City of Albuquerque Stormwater Construction Site Inspection Report

Project Name:	Ascension				
Location:	8814 Horizon				
Site Contact Name & Agency	Brian McCarthy brian@Abrazohomes.com	ESC File No.	B17E006		
		NPDES Id. No.	NMR1002JR		
Inspection Date:	03/12/20	Start/End Time:	0820/0845hrs		
CoA Stormwater Inspector:	Timothy E. Sims				
Construction Phase:	earthwork				
Type of Inspection:	☒ Regular	☐ Storm Event	☐ Post Storm Event >0.25"	☐ 311/Complaint	☐ Follow Up

NPDES POSTING BOARD

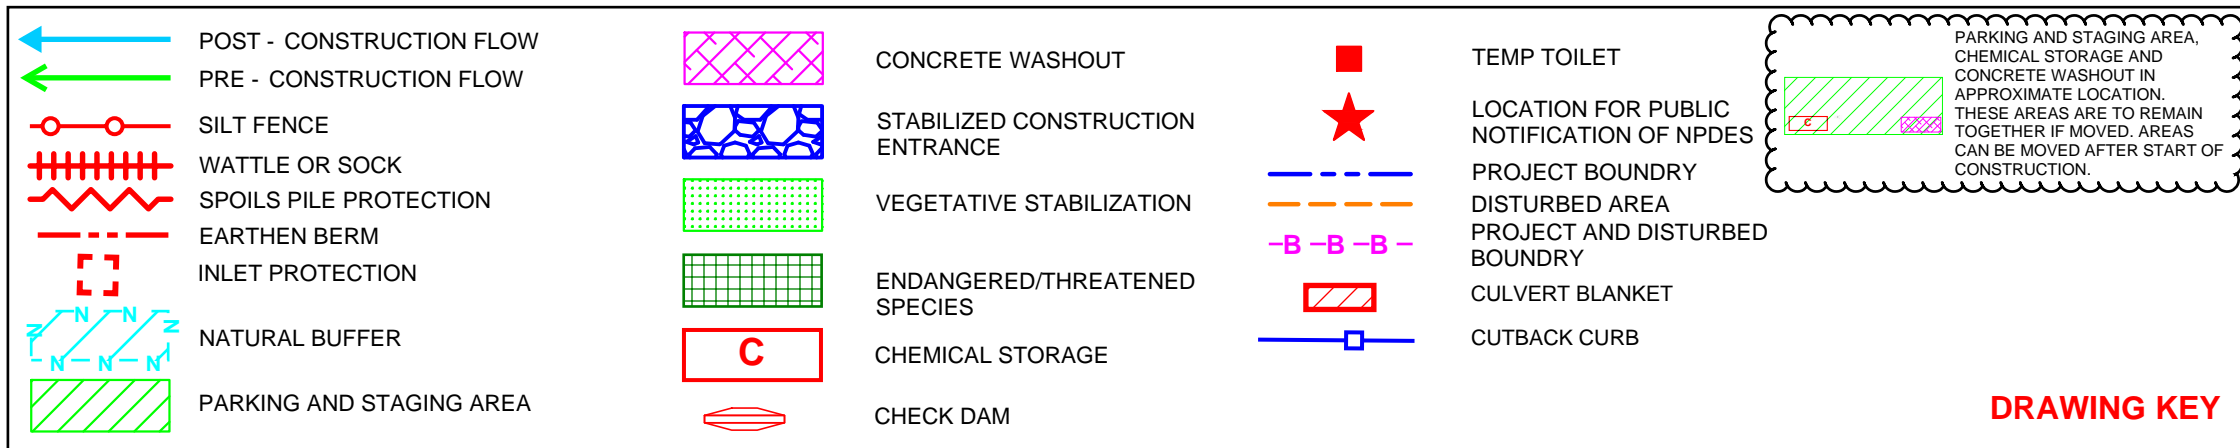
Item Number	Deficiency/ Corrective Action		
1	re-post the NPDES sign		
2.1	Discharge off site? (Y/N)	No	
4	Self Inspection Reports		Latest report Date: 3/2/2020
